WEST SUSSEX COUNTY COUNCIL CONSULTATION

TO:	Arun District Council FAO:Simon Davis
FROM:	WSCC - Highways Authority
DATE:	24 September 2020
LOCATION:	Garth House High Street Bognor Regis PO21 1HQ
SUBJECT:	BR/122/20/OUT Outline application with some matters reserved for demolition of Garth House and West View to be replaced with 20No. self contained apartments consisting of 10 No. 1 bed and 10 No. 2 bed apartments
DATE OF SITE VISIT:	n/a
RECOMMENDATION:	No Objection
S106 CONTRIBUTION TOTAL:	n/a / £ See below for breakdown.

Proposed Ground Floor Plan

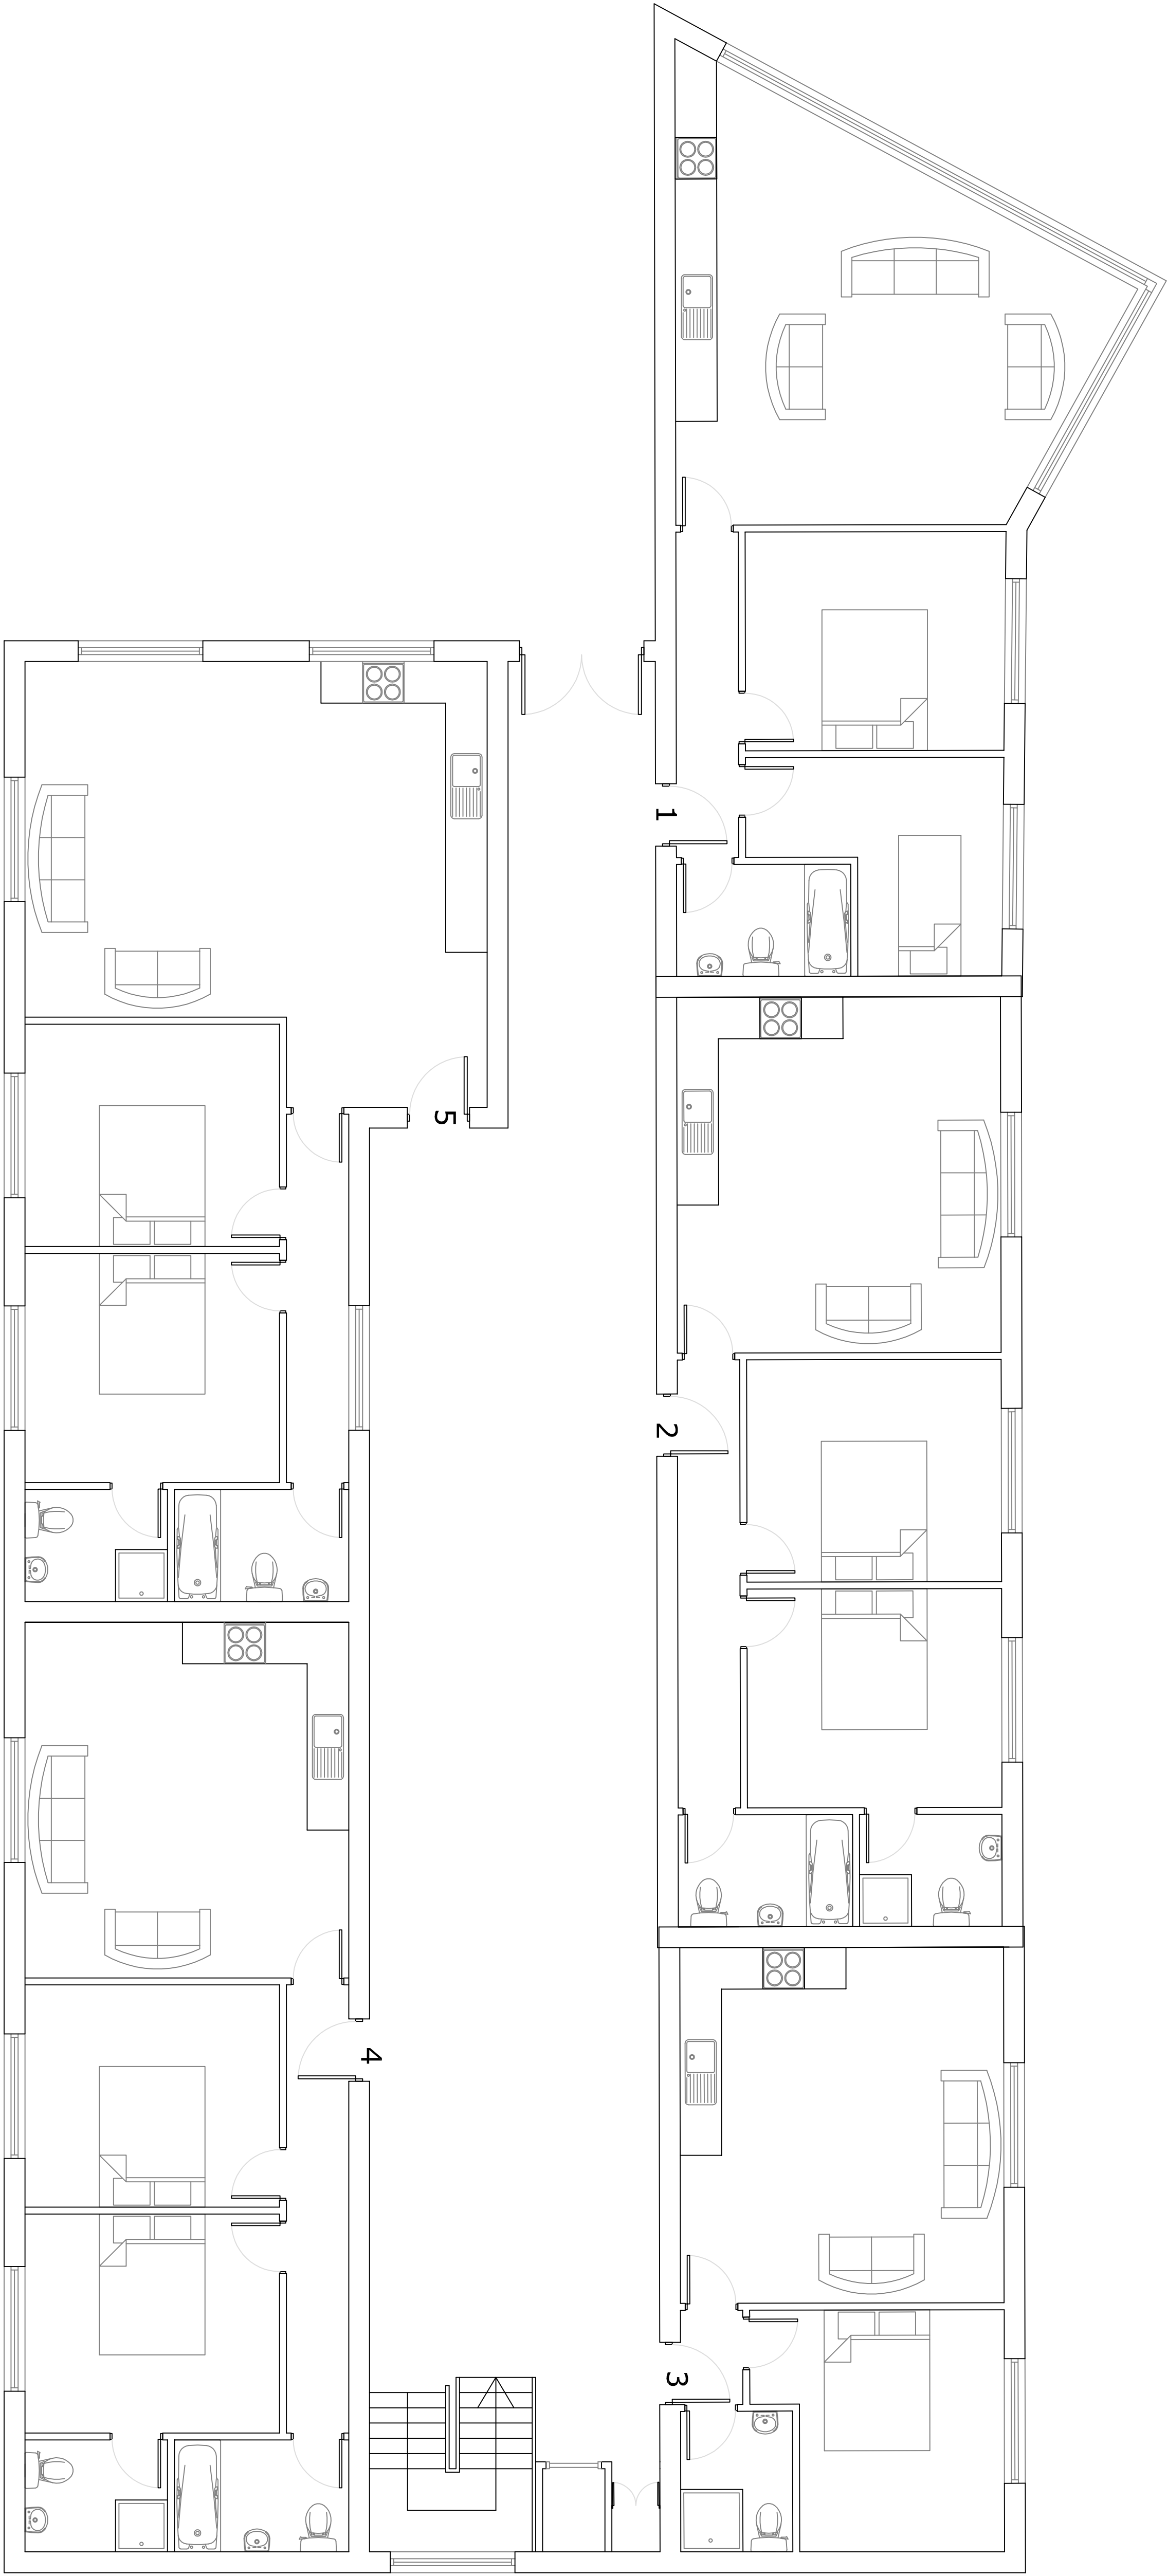
However; in terms of pedestrian access WSCC would expect to see at least 2.5m provided to ensure pedestrians and those requiring a wheelchair can pass each other easily. Guidance on footway widths are taken from Manual for Streets (Mfs) and inclusive mobility.

Cycle parking will be provided, as per WSCC guidance of 0.5 spaces per flat, equating to 10 spaces. Plans submitted show the location of these; but no information is provided regarding security, and if they will be covered. Given its town centre location, cycle storage like this should be less visible from the highway. At present they appear to be located at the front of the building which does not seem to be very secure.

No part of the development shall be first occupied until covered and secure cycle parking spaces have been provided in accordance with plans and details submitted to and approved by the Local Planning Authority.
